PROJECT TITLE: Gonzales Office Building

CITY ADDRESS: 7814 MENAUL

REF: GONZALES OFFICE BUILDING (H19-D33) RECEIVED AUGUST 16, 1985

A preliminary review of your submittal for Building Permit approval has shown that the following information is lacking for this section to begin the review process:

GRADING & DRAINAGE PLAN

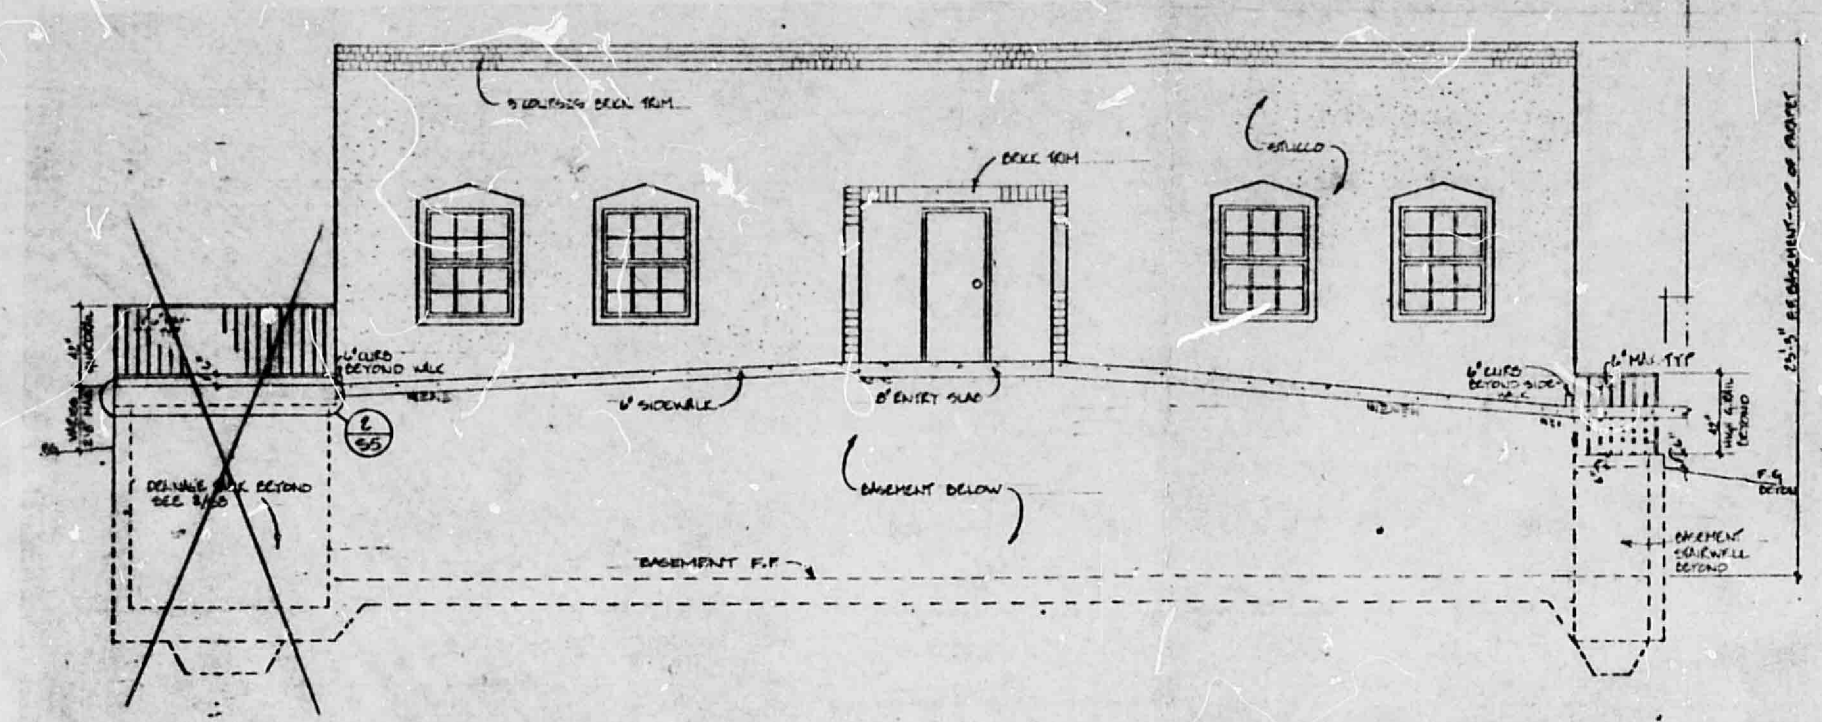
1. Given the existing conditions the existing CMU wall capturing the off-site flows and routing them along the wall towards the west. You are improving the situation by routing the development runoff towards Menaul. Therefore, redesign for permissible flows on the rear portion.
2. You are not allowed to pond the off-site flows in the rear yard, just let them continue to their historical pattern.

1. You may want to verify the finish floor elevation on the existing building, seems kind of high compared to the existing contours.
